BEACON FEN ENERGY PARK

Planning Inspectorate Reference: EN010151

Chapter 6 – Landscape and Visual
Document Reference: 6.2 ES Volume 1, 6.2.6 Chapter 6
~~April~~ December 2025

Figure 6.2 Screened Zone of Theoretical Visibility with Viewpoints

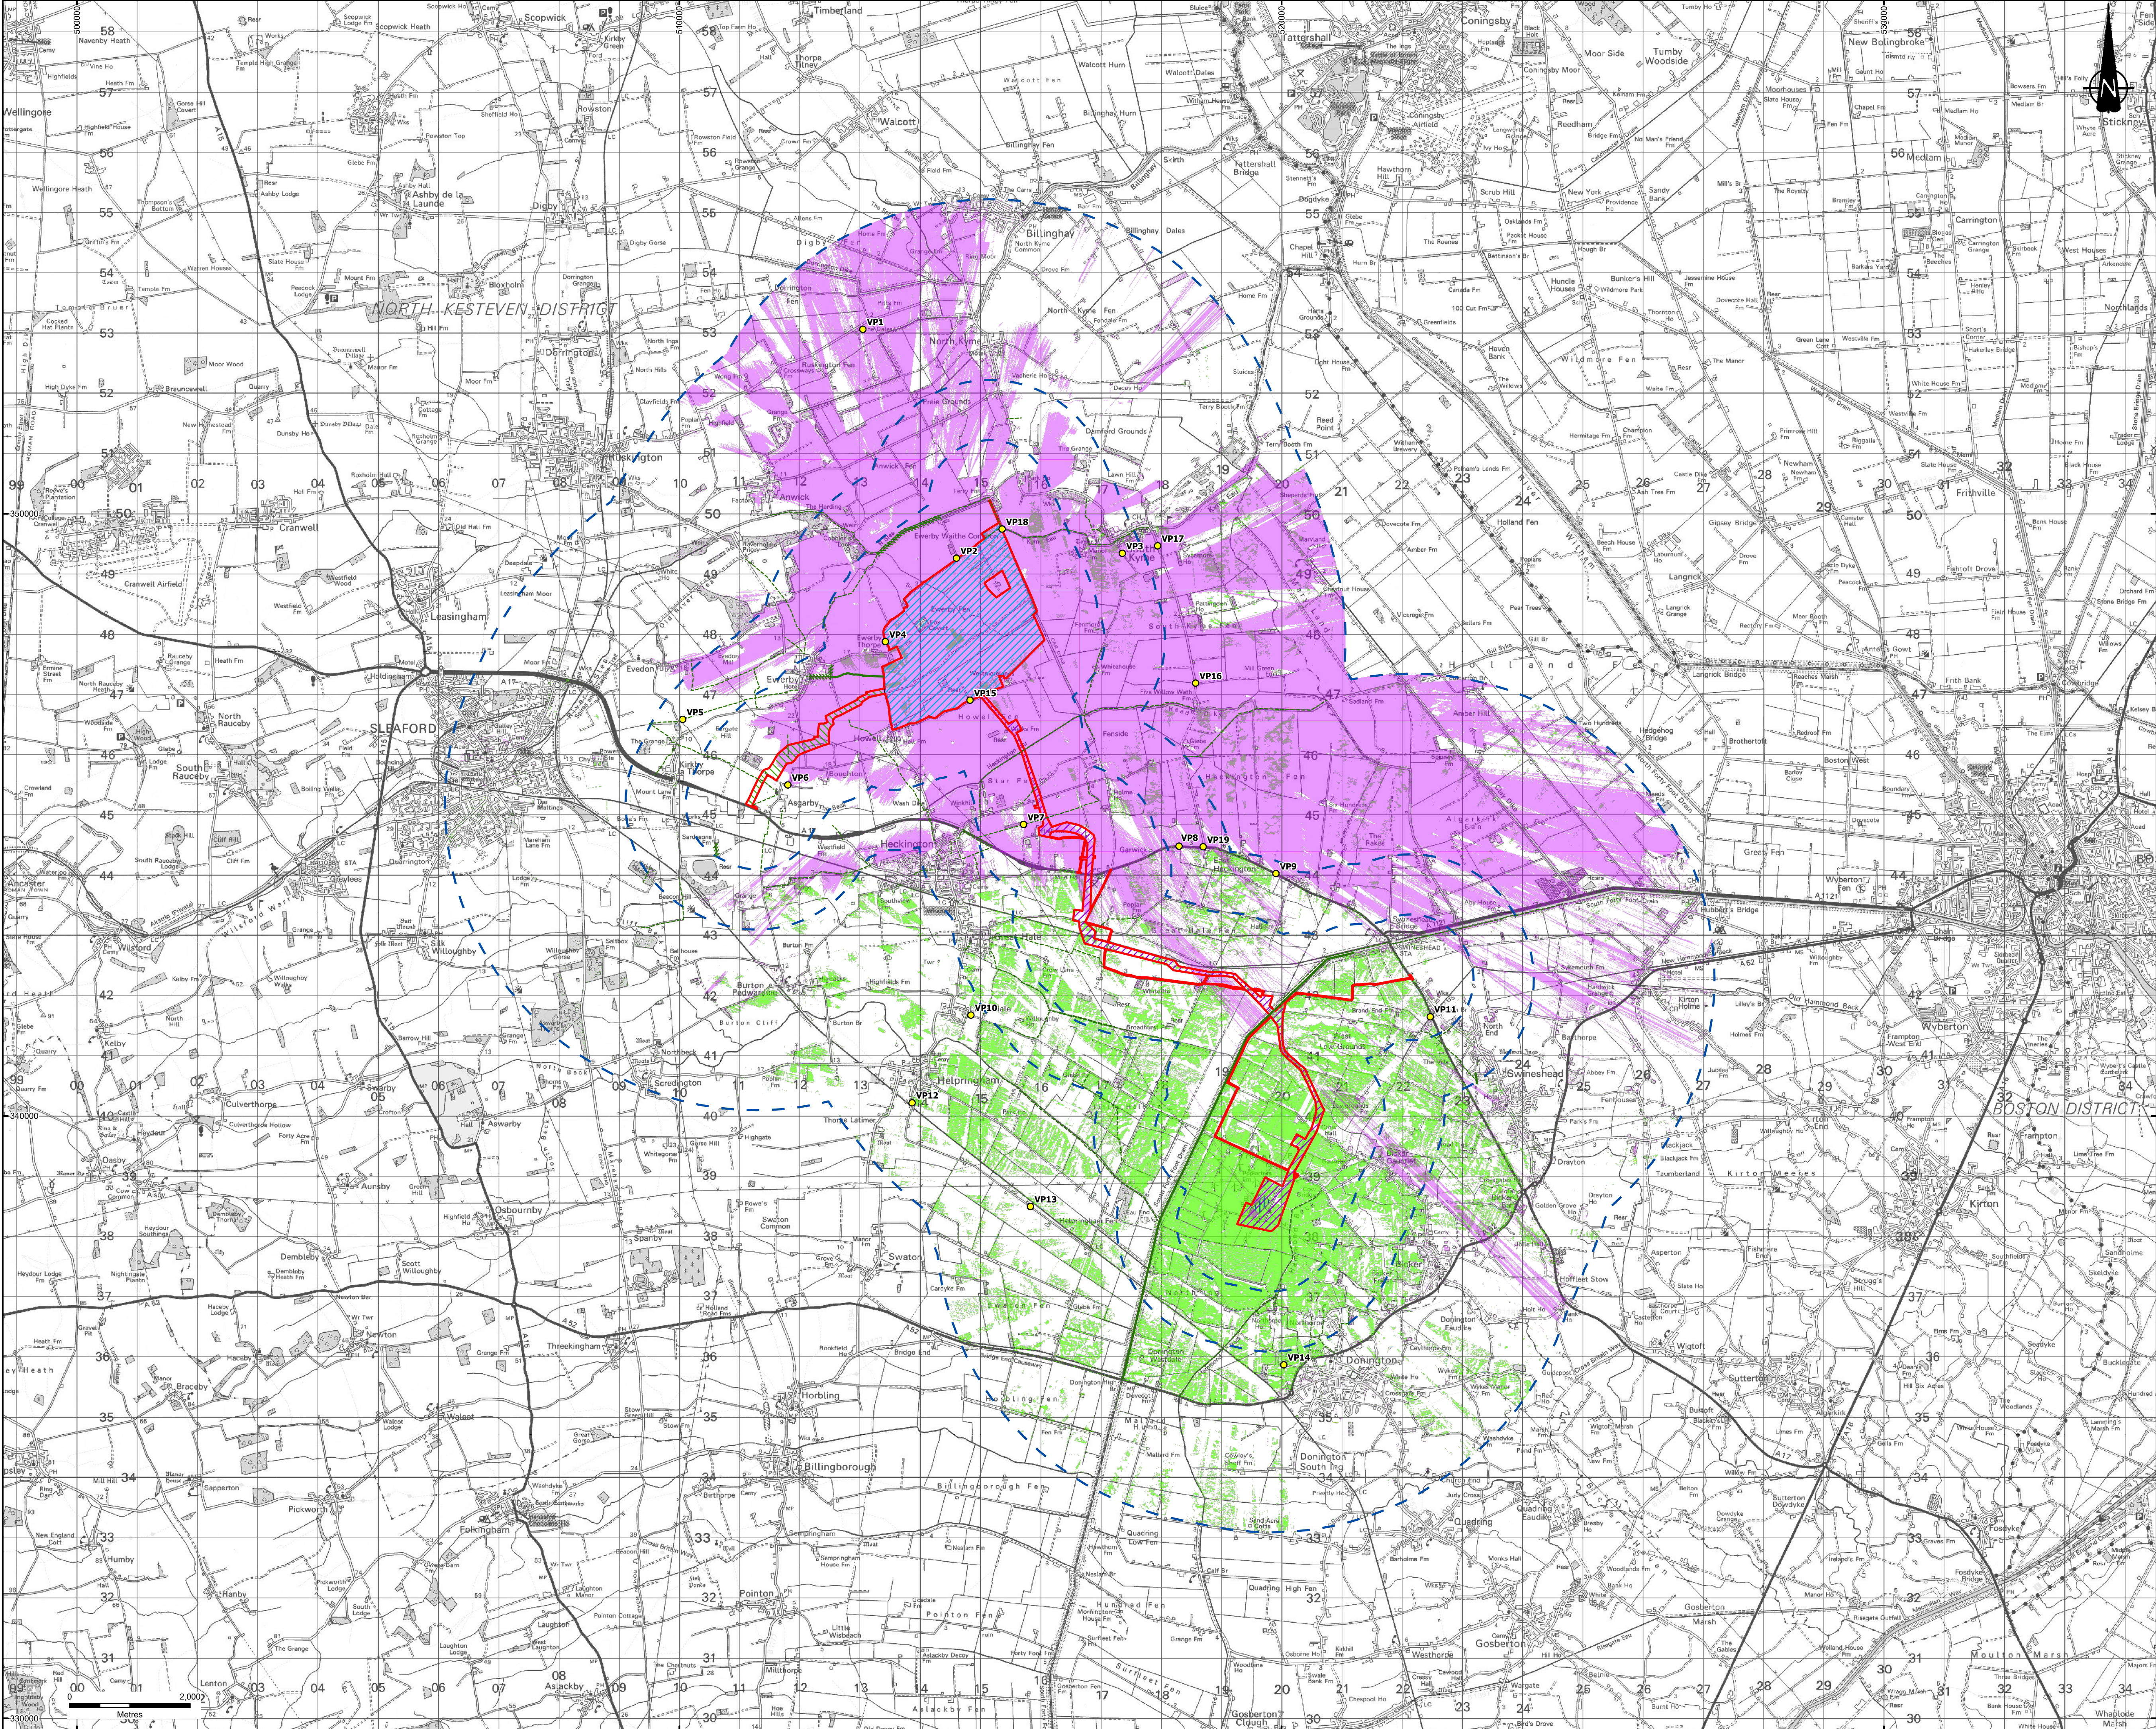
ORGANISATION	DATE	FORM OF CONSULTATION	REQUEST	SUMMARY OF RESPONSE
PINS	26 May 2023	Scoping Opinion	Zones of Theoretical Visibility (ZTVs) Bareground and Screened ZTVs are provided within the Scoping Report at Figures 4.1 and 4.3 respectively. It is noted (in paragraph 4.5.2) that these ZTVs are based on maximum panel heights of 4.5m. However, there are other components of the Proposed Development which have a height greater than 4.5m, such as substation(s) of 11m height and CCTV poles of 5m. Paragraph 4.6.5 also states that it is assumed that the cable would be buried; however, it is noted in paragraph 2.5.4 that the option of using overhead line(s) instead of a buried cable cannot be ruled out. The final ZTVs, and subsequently the Landscape and Visual Impact Assessment (LVIA), should ensure that a worst-case scenario is assessed based on the maximum parameters of the Proposed Development, including any auxiliary infrastructure such as security camera poles, fences, or construction compounds (although the Inspectorate notes the Applicant's intention to	Updated ZTV's are provided as part of the Environmental Statement. The ZTV's are based on the maximum height parameters of the Proposed Development including 13m for the Onsite Substation within the Solar Array Area and 15m for the proposed Bicker Fen Substation Extension to the southern extent of the Cable Route Corridor. Two ZTV's are included as follows; Figure 6.1 Bareground Zone of Theoretical Visibility (Document Ref: 6.4 ES Vol.3, 6.4.12) which illustrates the worst case scenario and Figure 6.2 Screened Zone of Theoretical Visibility (Document Ref: 6.4 ES Vol.3, 6.4.13) which includes the screening effects of intervening vegetation and built form.

ORGANISATION	DATE	FORM OF CONSULTATION	REQUEST	SUMMARY OF RESPONSE
			monitoring requirements and consider the potential for vegetation planting as a form of mitigation to be affected by climate change. To allow for documents to be certified within the DCO, as a mechanism to secure the mitigation, the application documents should ensure that the naming convention is consistent between the documents and the appropriate Schedule of the DCO.	
North Kesteven District Council and Lincolnshire County Council	18 May 2023	Scoping Opinion Response (Joint response from North Kesteven District Council and Lincolnshire County Council informed by Appendix 1. Landscape Scoping Report Review by AHH Consultants (May 2023))	Viewpoints. Figures 4.1 and 4.3 of the scoping report identifies 16 proposed viewpoints across the two PV sites and the area identified for the cable connection to the sub-station. AAH have undertaken a site visit in early May 2023, and the site characteristics suggest that these viewpoints need to be supplemented by additional ones from further distances in all directions. The selected 16 appear to be appropriate for closer scrutiny of sensitivity, however the final locations and number of viewpoints are to be agreed with LCC and other relevant stakeholders.	Following further consultation further viewpoints have been added including further long distance views to the south east the locations of which are shown in Figure 6.2 Screened Zone of Theoretical Visibility (Document Ref: 6.4 ES Vol.3, 6.4.13).
